**RE: Holiday Inn Express – Copper Pointe
Conceptual Grading Plan
Engineer's Stamp Date 12-29-2015 (File: K21D009H3)**

Based upon the information provided in your submittal received 12-29-2015, the above referenced Conceptual Grading Plan is approved for Site Plan for Building Permit and DRB Action.

Project Title: Holiday Inn Express - Copper Pointe Subdivision

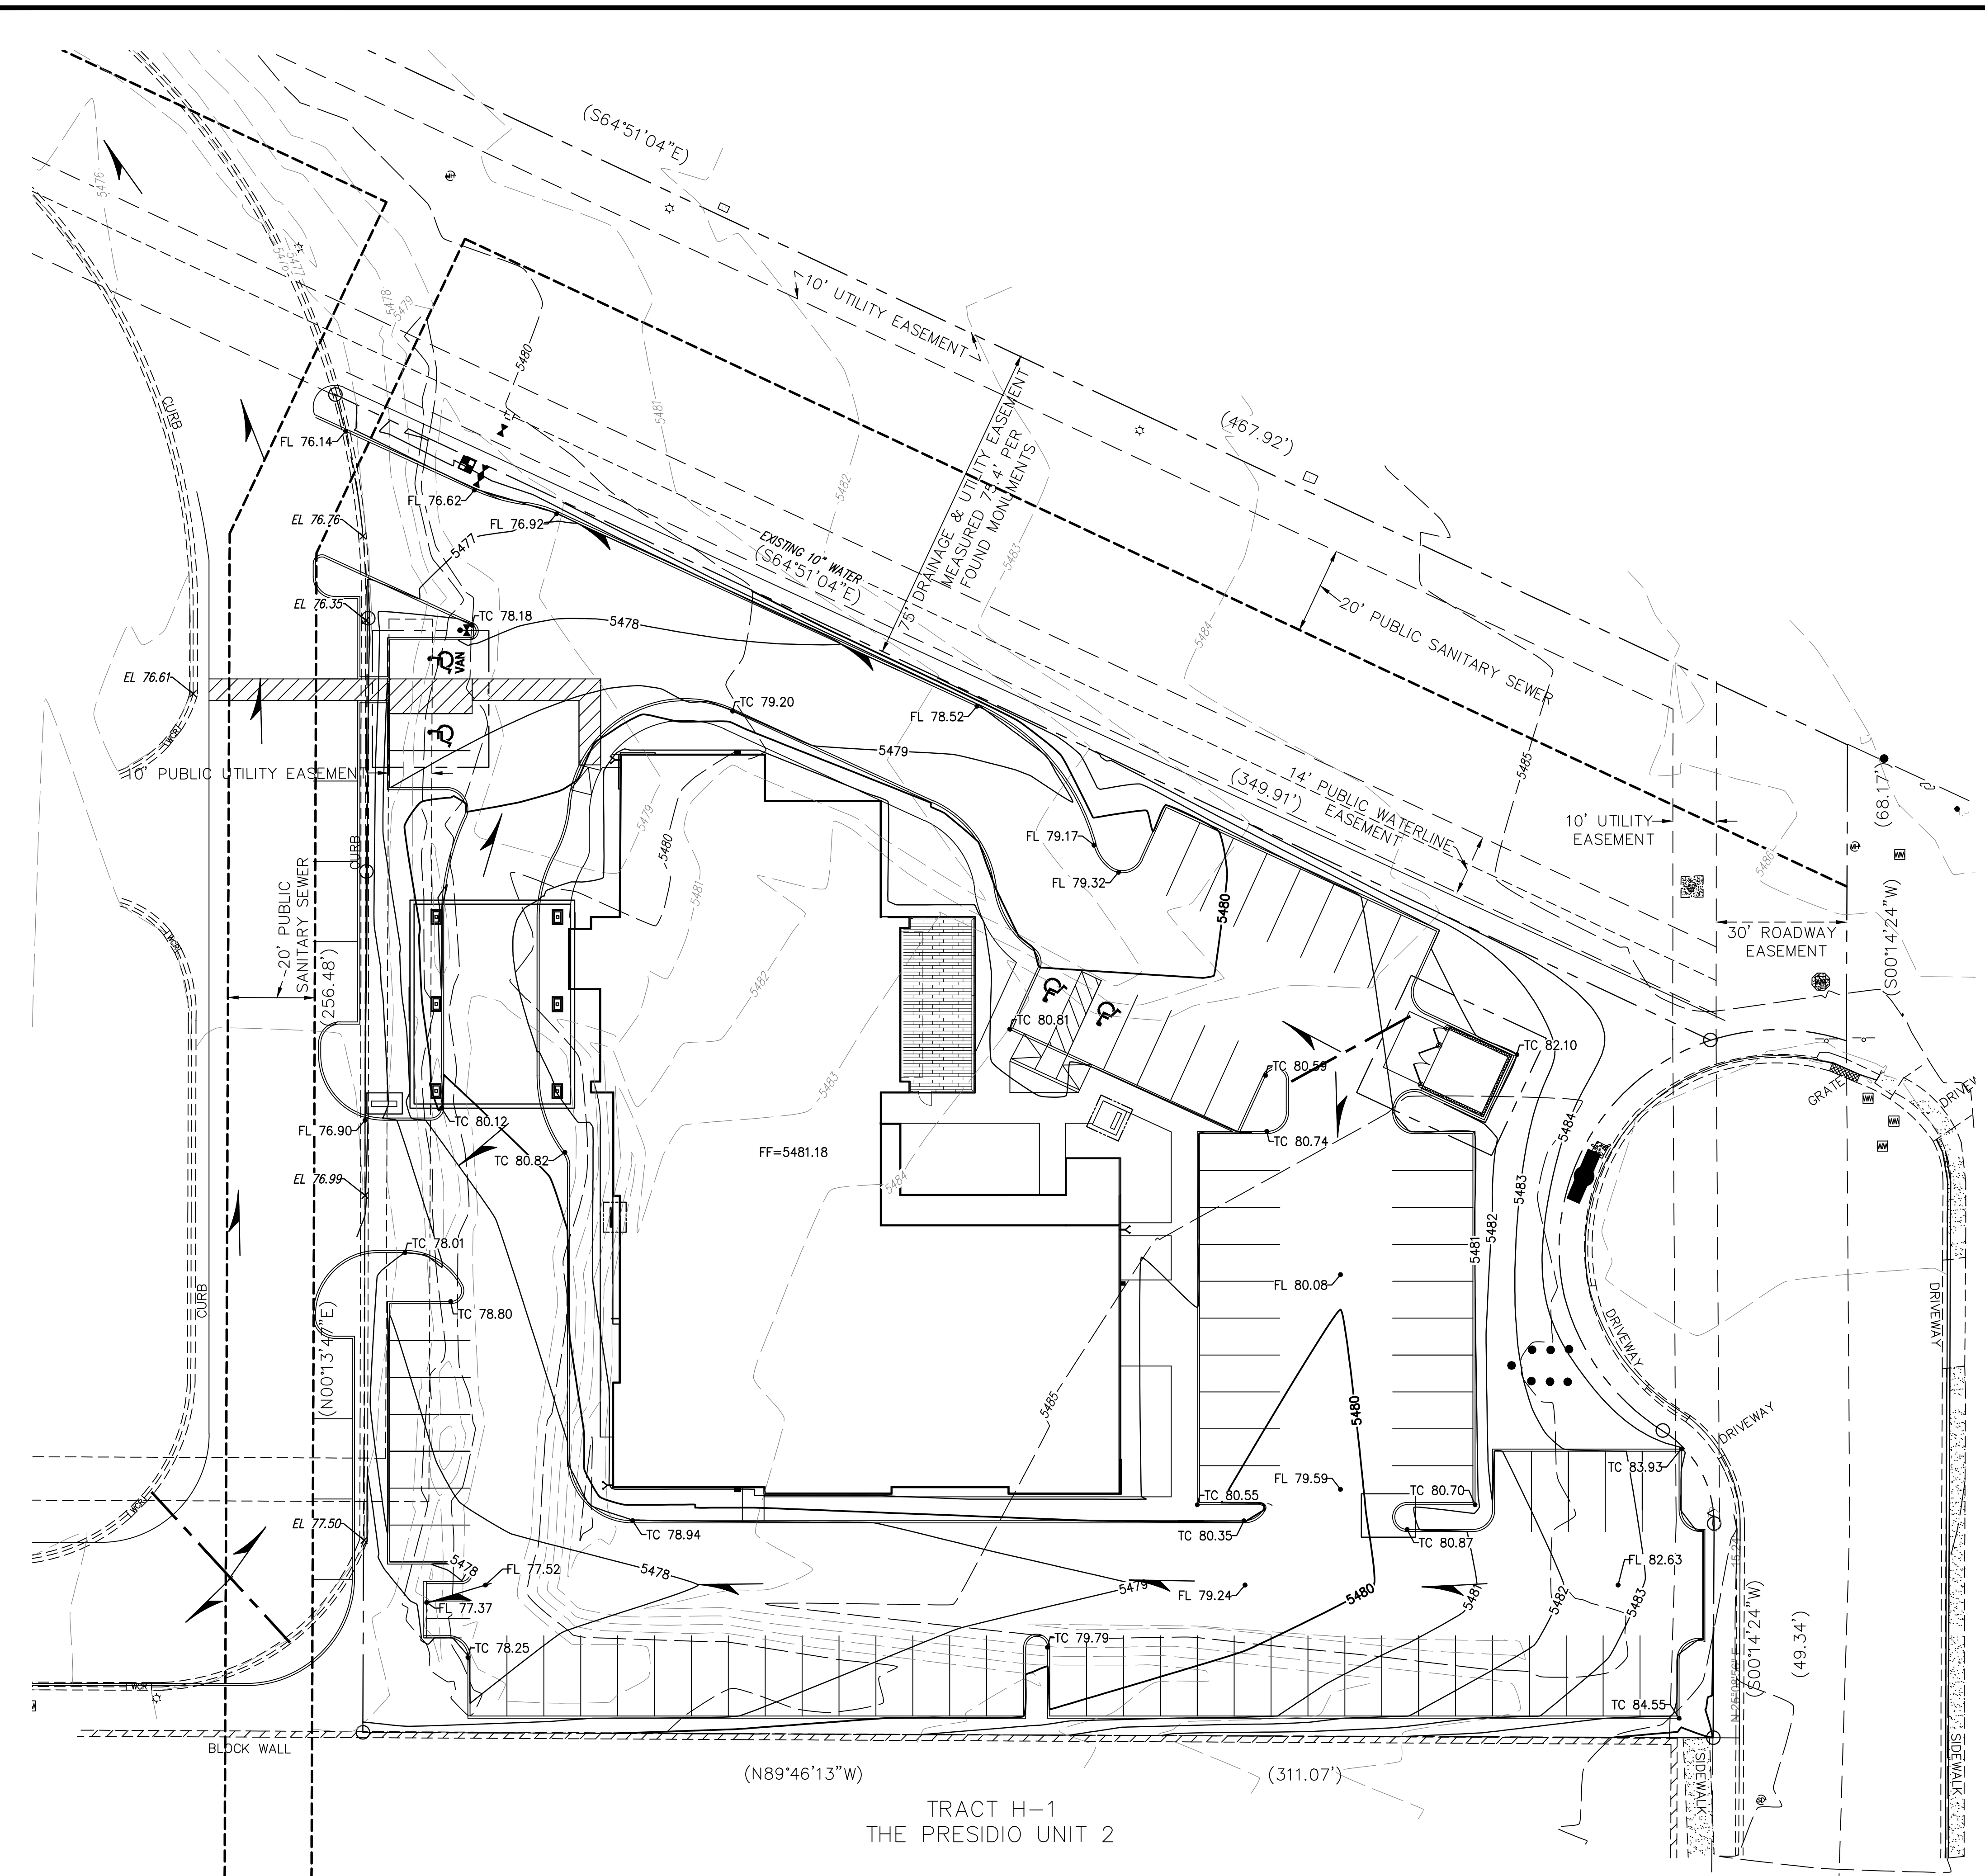
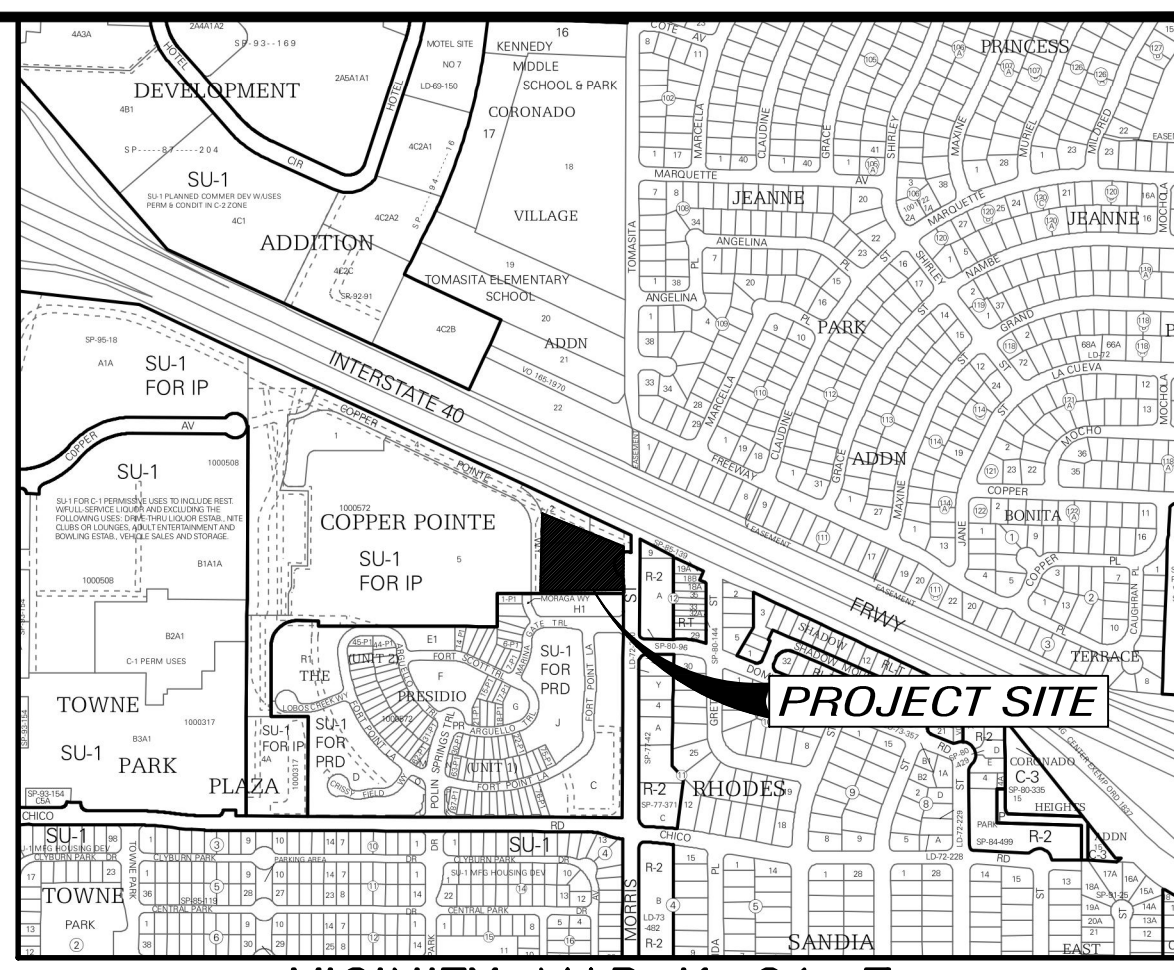
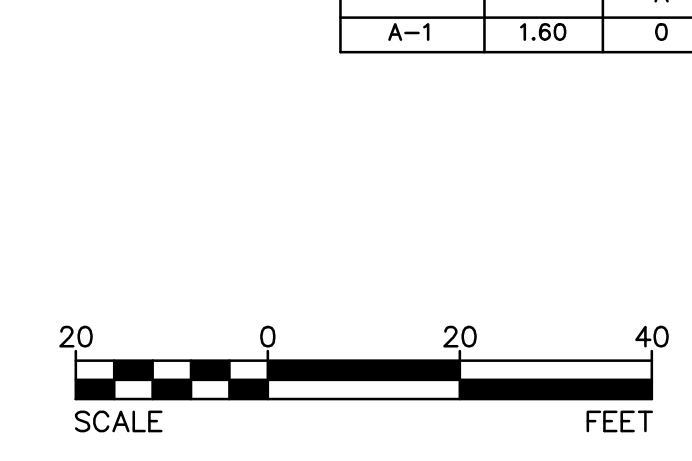
The drainage narrative states that the first flush will be stored in the perimeter landscaping areas. However, the access aisle appears to be conceptually shown with an inverted crown, and grades within the medians don't reflect a ponding area. Please note that we will expect the Final Grading and Drainage Plan to clearly show that the first flush pond is provided, *and* that Stormwater is directed to it.
